Case Officer: Linda Griffiths

Proposal: Partial Discharge of Conditions 8 (proposed site and floor levels), 11 (drainage scheme), 25 (street lighting) and 32 (trees or hedgerows) of 14/01932/OUT relating to the new Bloxham Road Access

DATE: 16 March 2021

Drawing Title: **S278 WORKS ROUNDABOUT BALANCING POND X-SECTION**

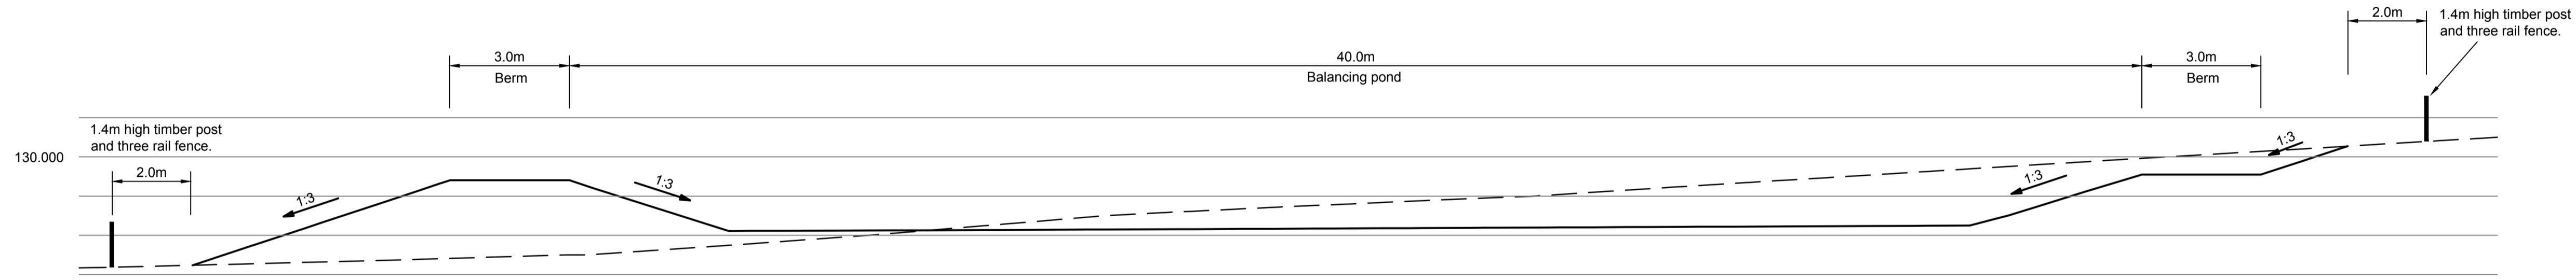
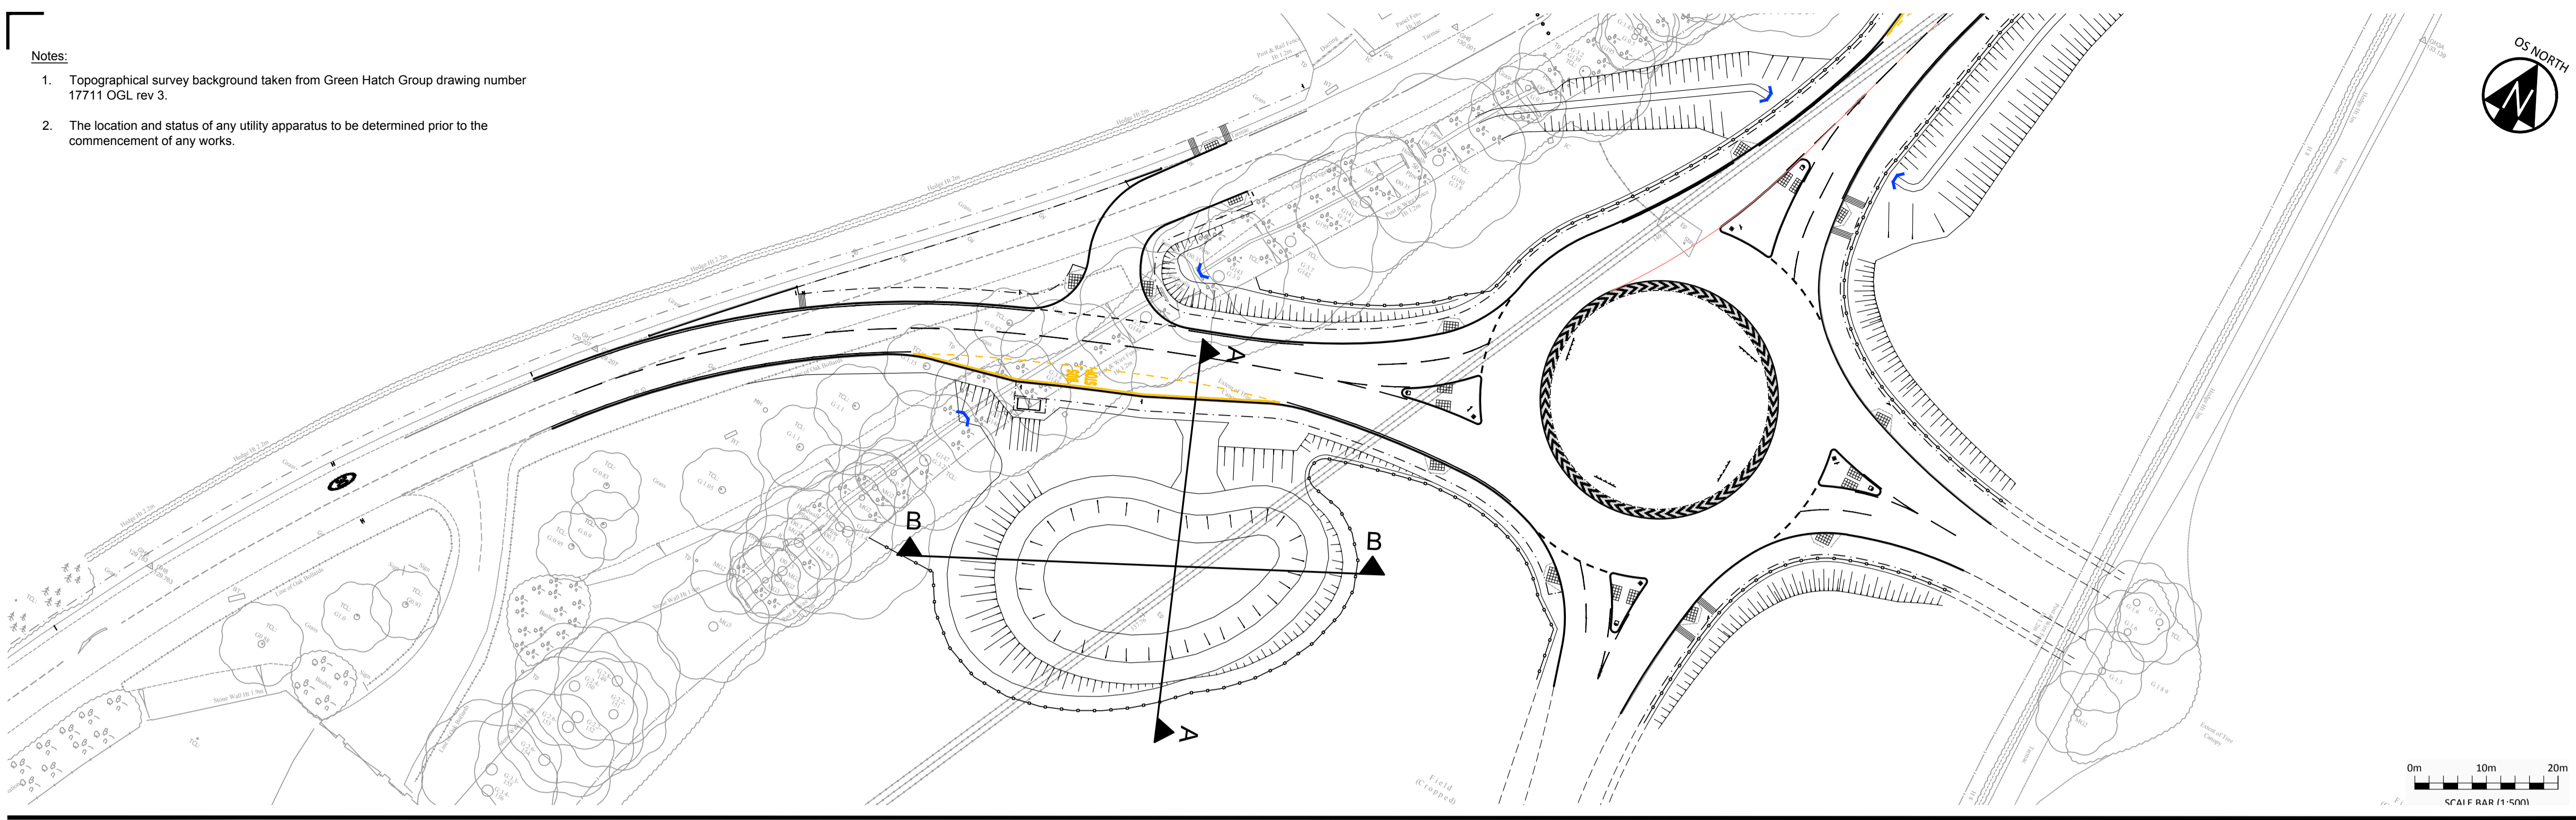
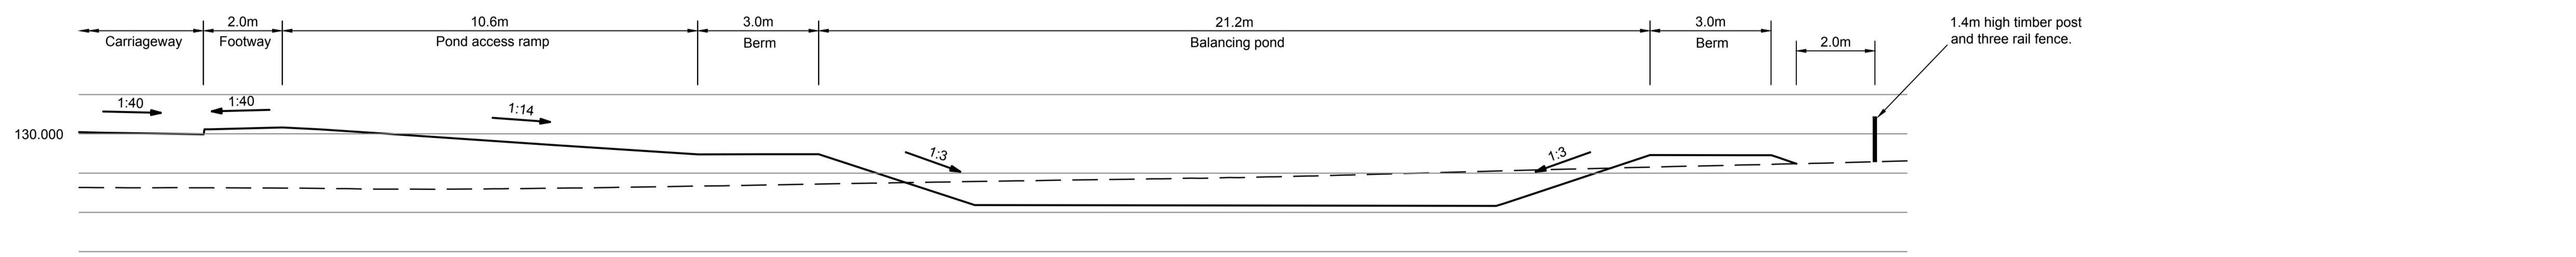
4.2 CDC Landscape Officer: concerns about depth of attenuation basin which has no overflow and no construction detail for the headwall into the basin.

- 5.2 Condition 11 – relates to the drainage details. As above, these have been assessed by OCC and the drawings are included in the S278 Technical Audit Certificate. CDC Landscape raised a concern regarding the depth of the attenuation basin and the lack of detail for the headwall into the basin. As OCC have raised no objection and the drawings have already been technically approved under S278, it is considered that the proposals are acceptable.

Drawing Title: **S278 WORKS ROUNDABOUT GENERAL ARRANGEMENT**

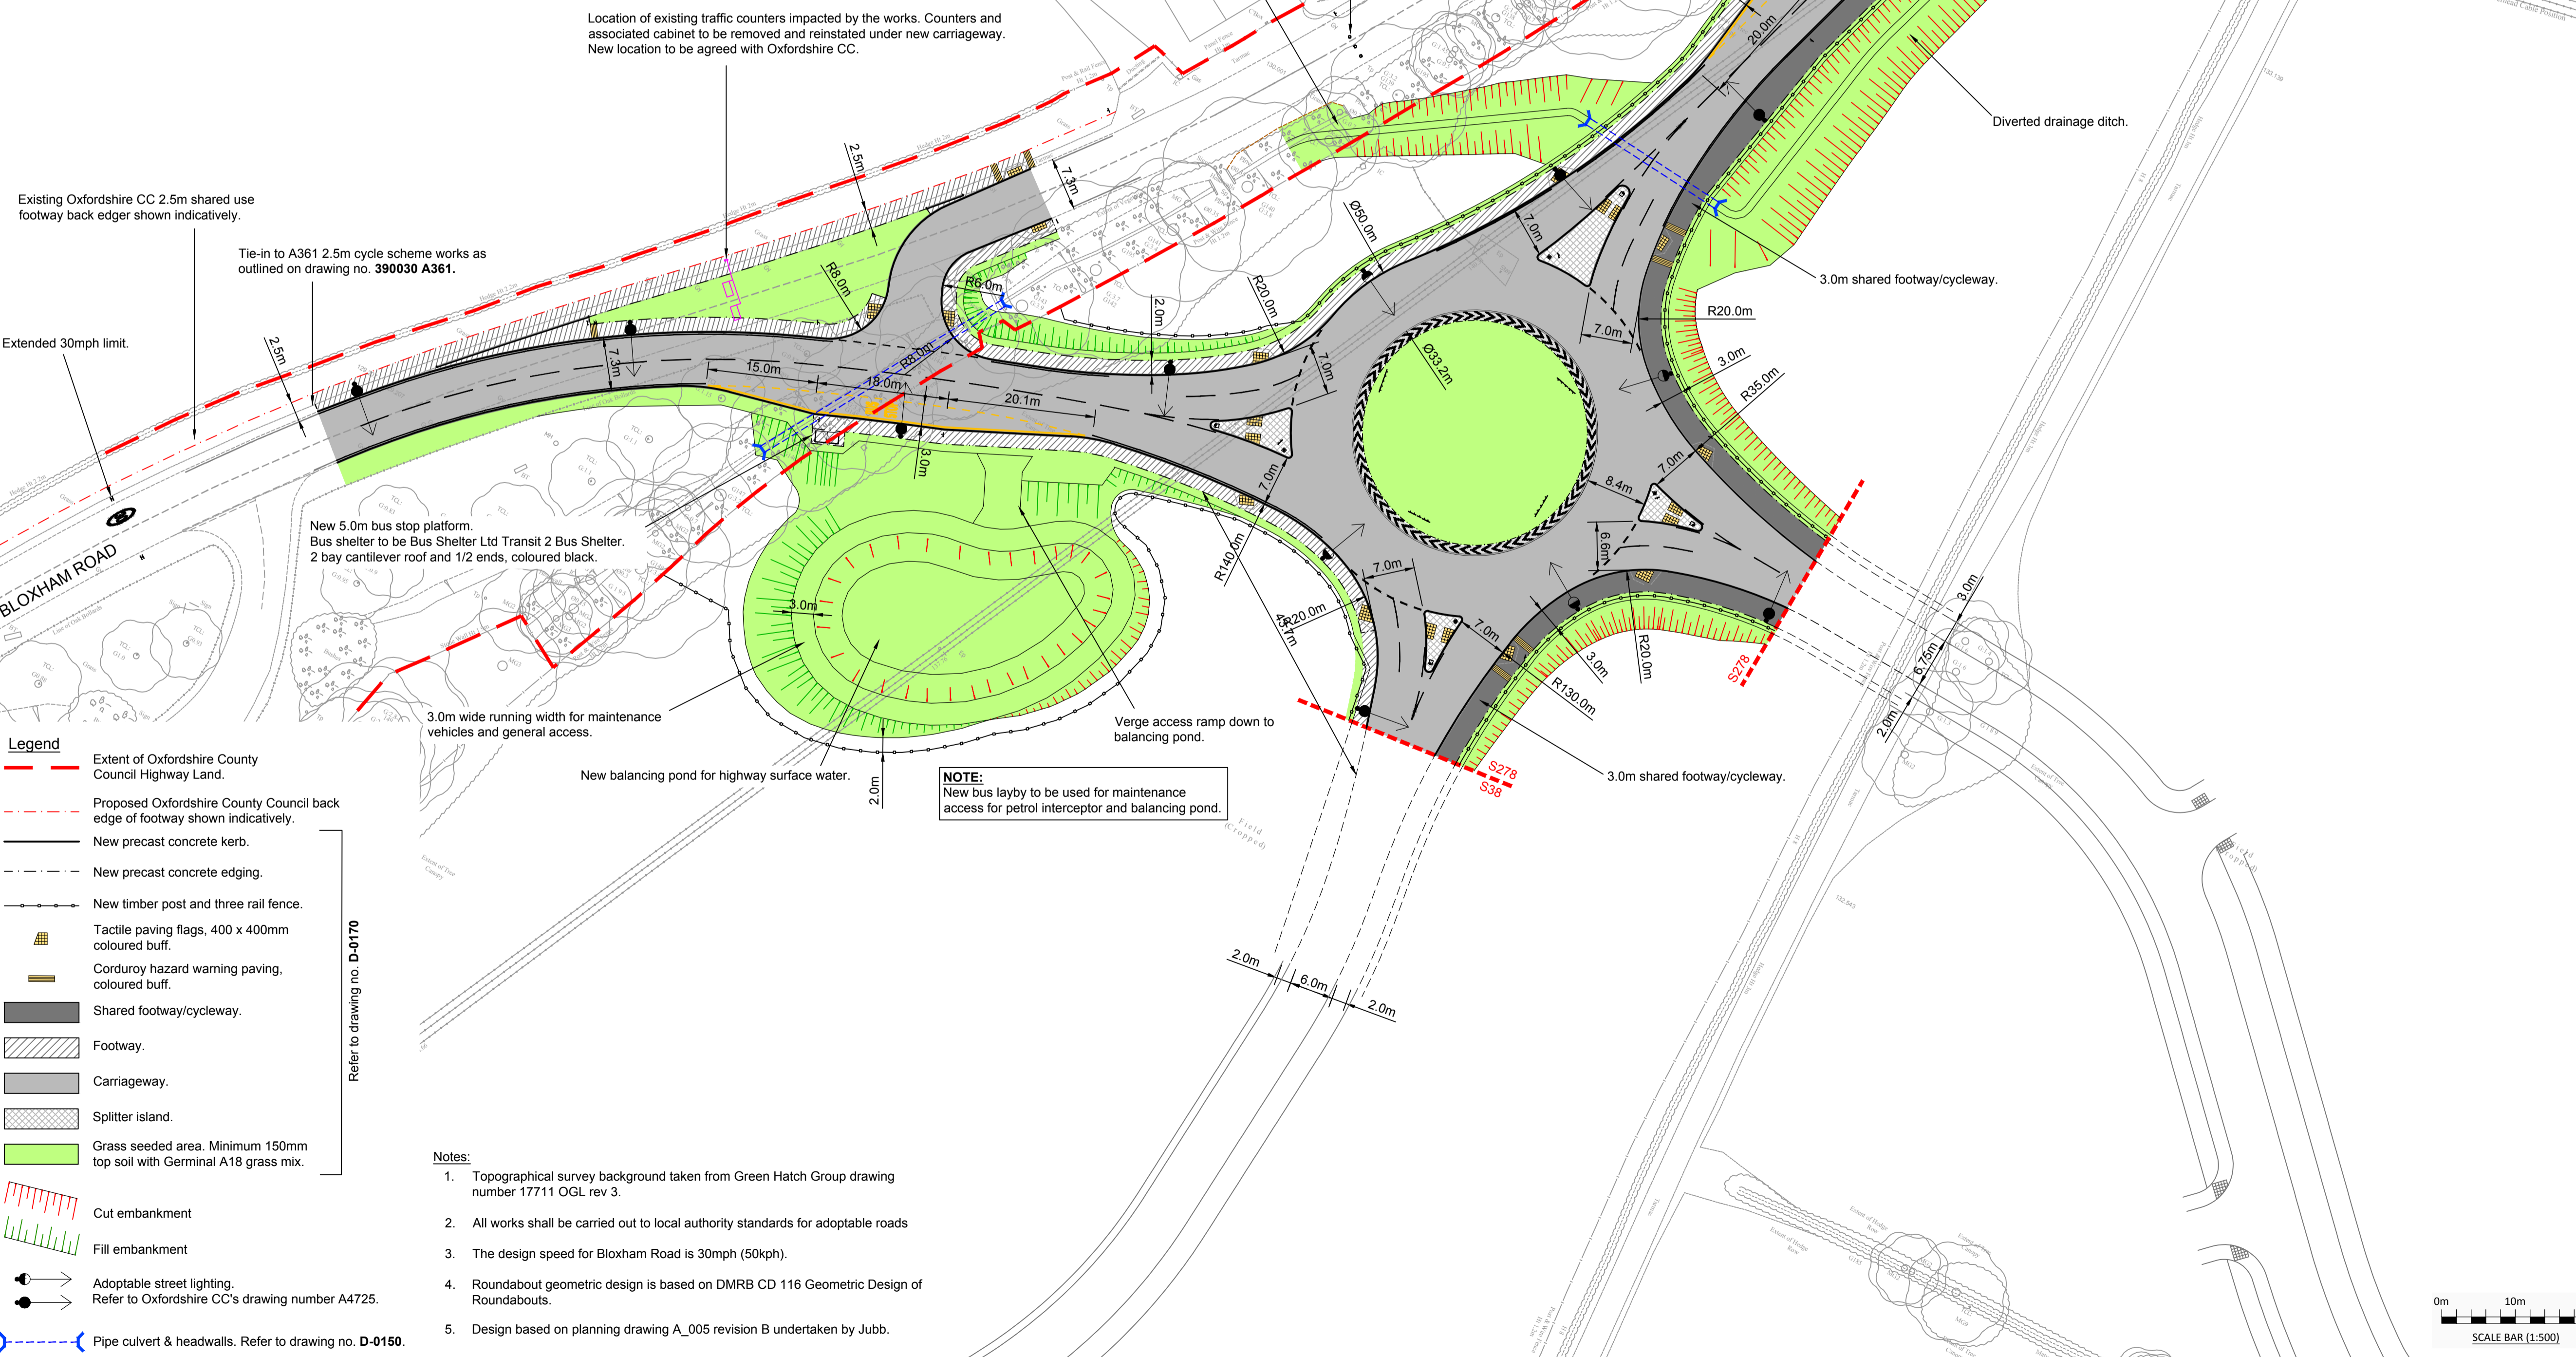
- 5.3 Condition 25 – Street lighting. The positions are shown on the plans and accord to OCC's adoptable specifications. OCC have raised no objections and are therefore considered acceptable.

Drawing Title: **S278 WORKS ROUNDABOUT SITE CLEARANCE**

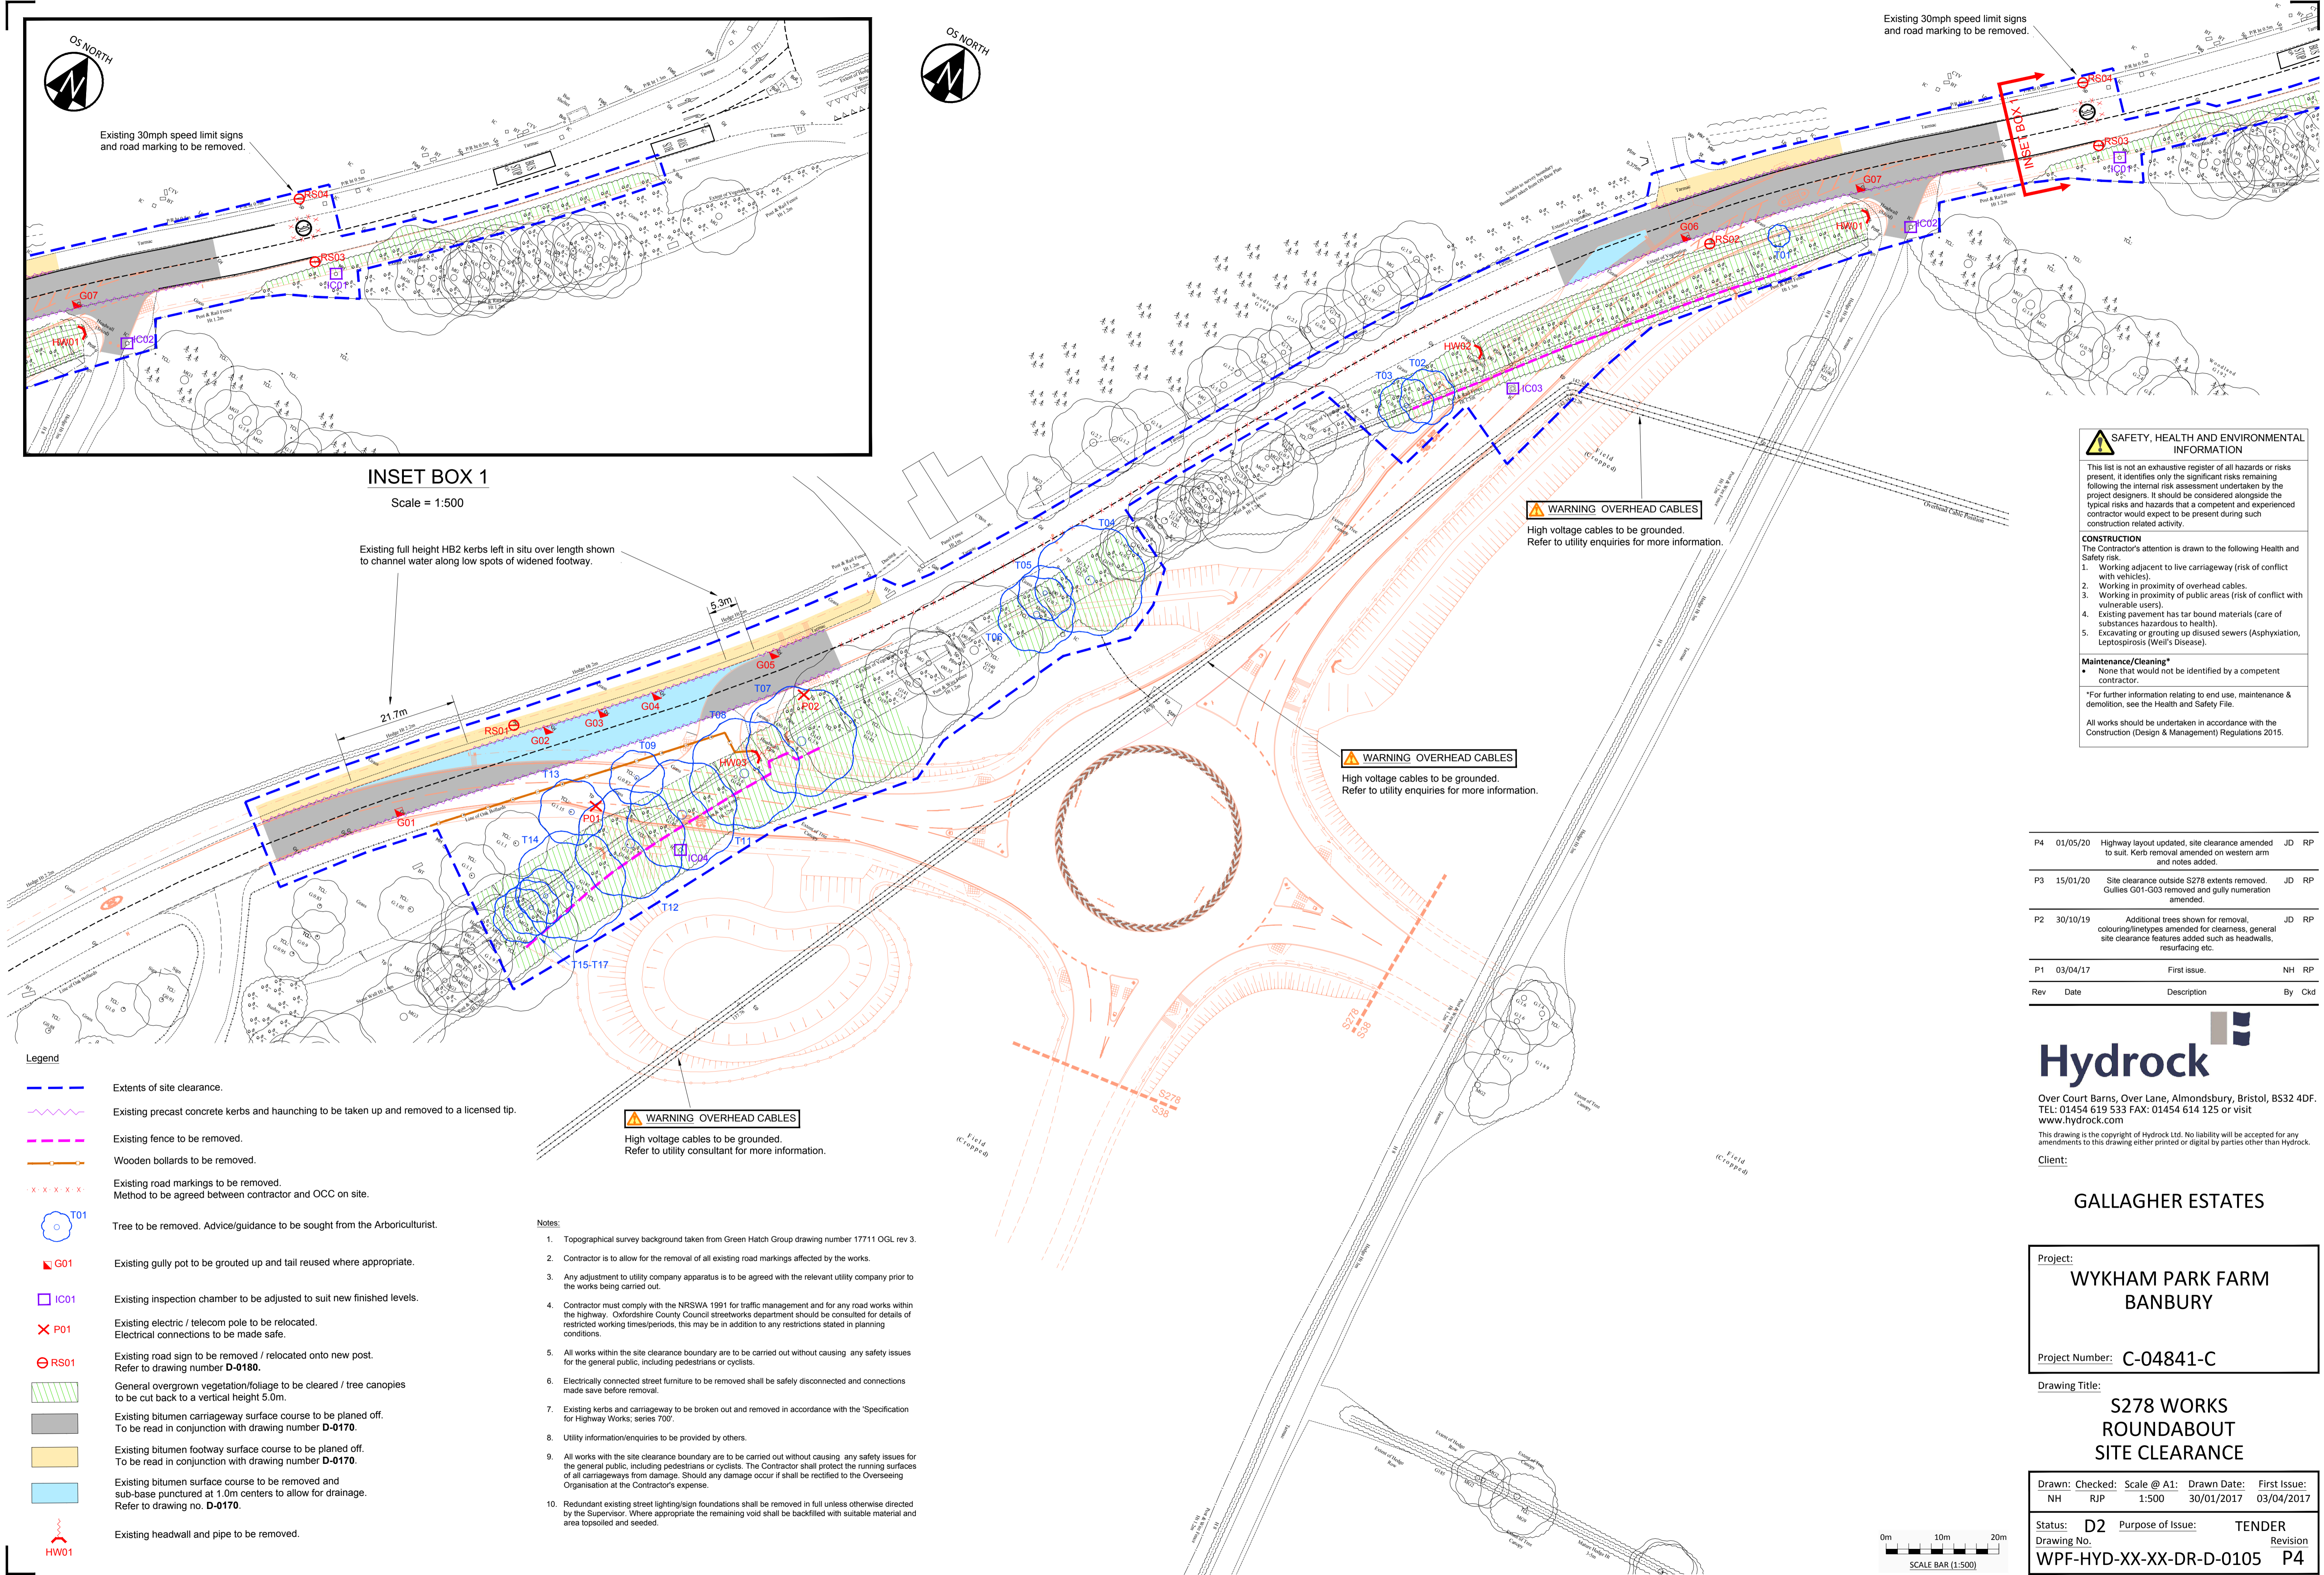
- 5.4 Condition 32 – relates to the removal, lopping or topping of trees and hedgerows unless directly necessary for the development. In this case, a number of significant trees and line of hedgerow have been removed to facilitate construction of the new access and roundabout into the site. The removal shown is necessary and acceptable.
